**Deadline 6 Submission on Cumulative Effects**

**Planning Inspectorate Reference: EN010159 – One Earth Solar Farm**

**Date: 03/12/25**

Figure 4.1: Barred Route Plan

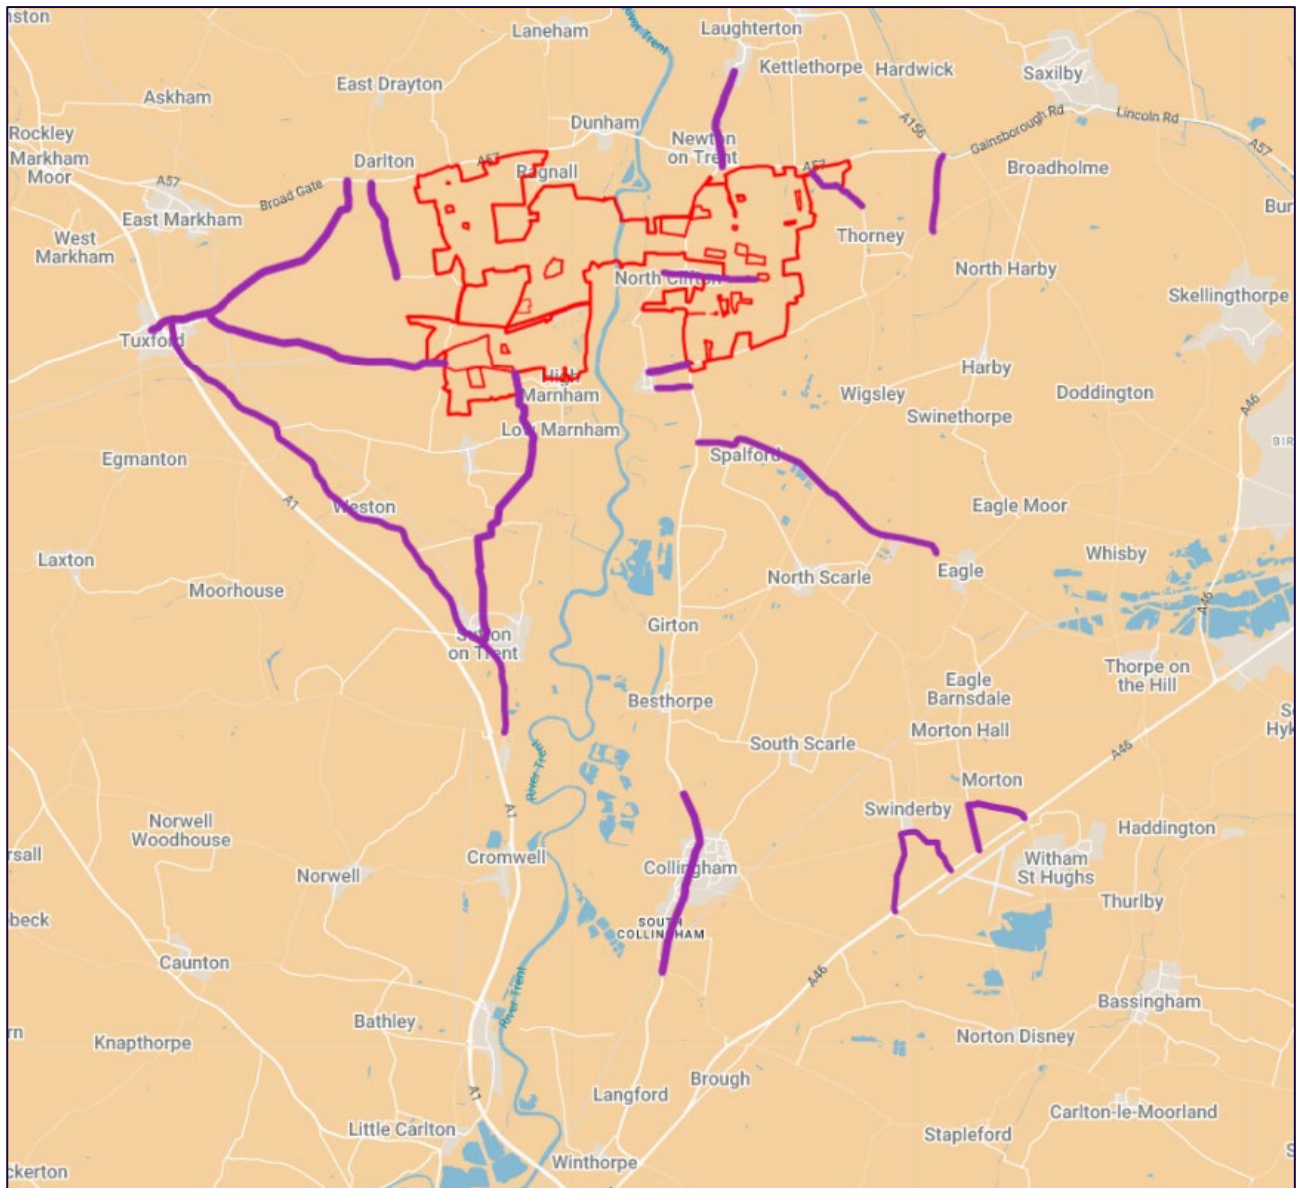
This is particularly concerning as local authorities (NCC, NSDC, LCC) have already raised uncertainty regarding construction routing. The lack of a Barred Routes Plan further complicates the ability to consider cumulative effects on vulnerable rural lanes such as Moor Lane in South Clifton.
